Application number: 2024/92645	
What is the application for?:	Raising roof height and associated external alterations to enable a loft convers
Address of the site or building:	23, Oldroyd Way, Dewsbury, WF13 2JJ
Postcode:	WF13 2JJ

User comments

01 Proposed North Side Elevation
Scale 1:50 @ A2

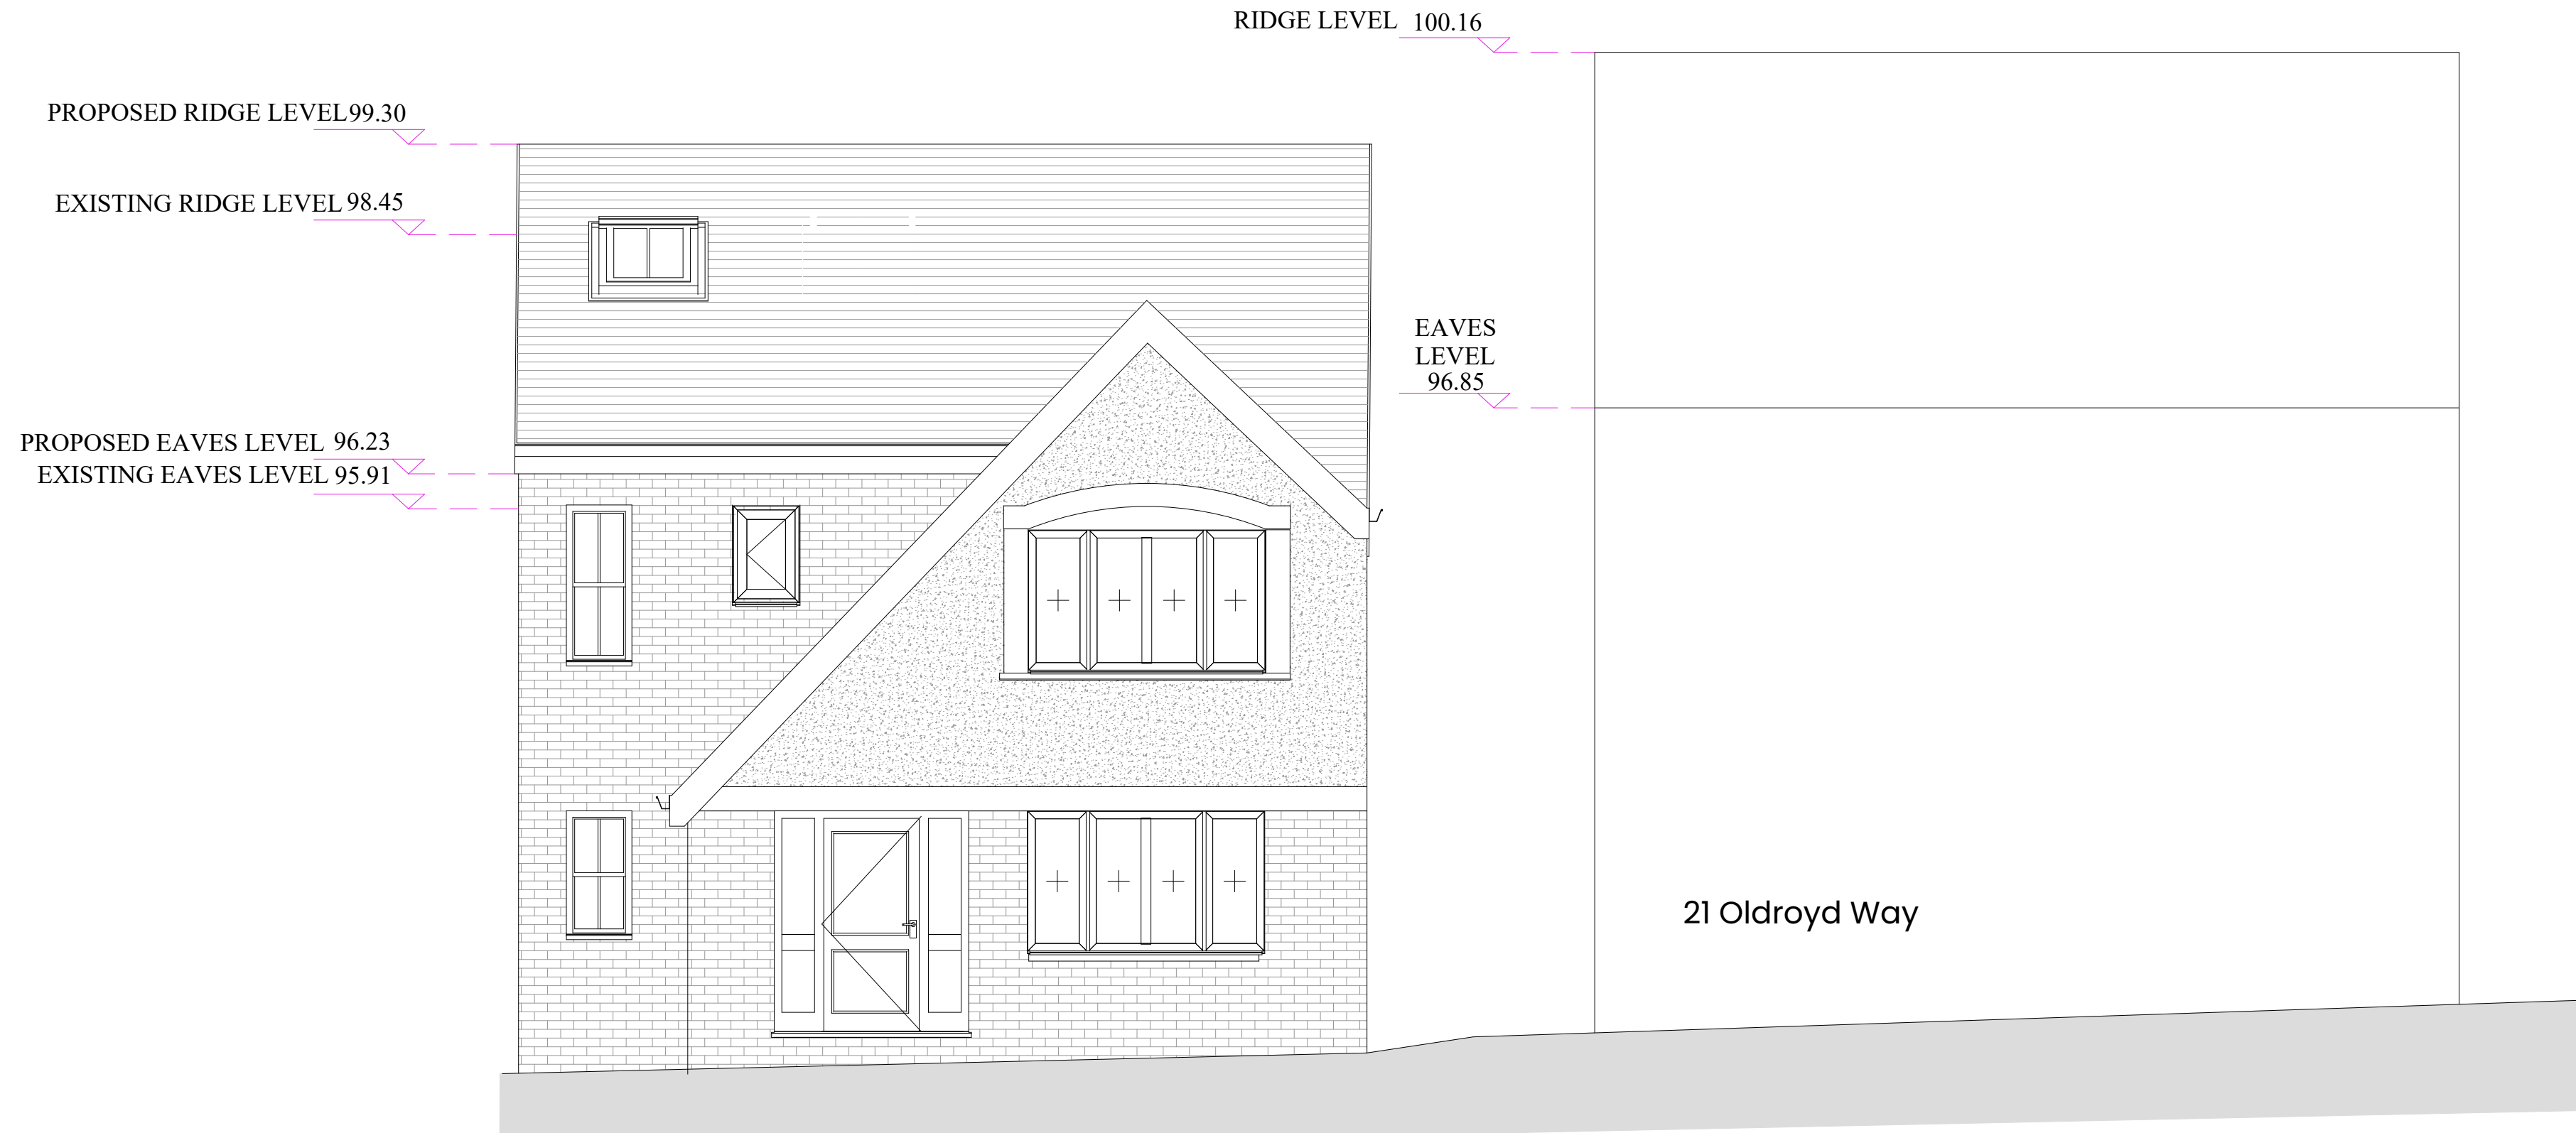
Type of comment: An objection	
Do you wish your comments to be published on the website anonymously?	No
The proposals to increase the height of the building and add dormer windows to provide additional accommodation are unacceptable. 1.The increased building height (to create a 3 storey development) will not be in keeping with adjacent properties, and will stand out as such. The proposals indicate that the existing property is being overdeveloped ,and will seriously affect the character of the area. 2.There is a potential safety issue here, the additional bedrooms will add additional people and thus increase the vehicular traffic to and from the building via an already small entrance drive and turning circle. 3.The increased height will add further to the loss of light to adjacent properties ,the light loss is already evident with the current building progress being made so far. 4.Additional Dorma and gable windows to the bedrooms on the third storey will allow further visual intrusion to adjacent properties. 5.The current building progress to date indicates that this is already an unacceptable imposing development.
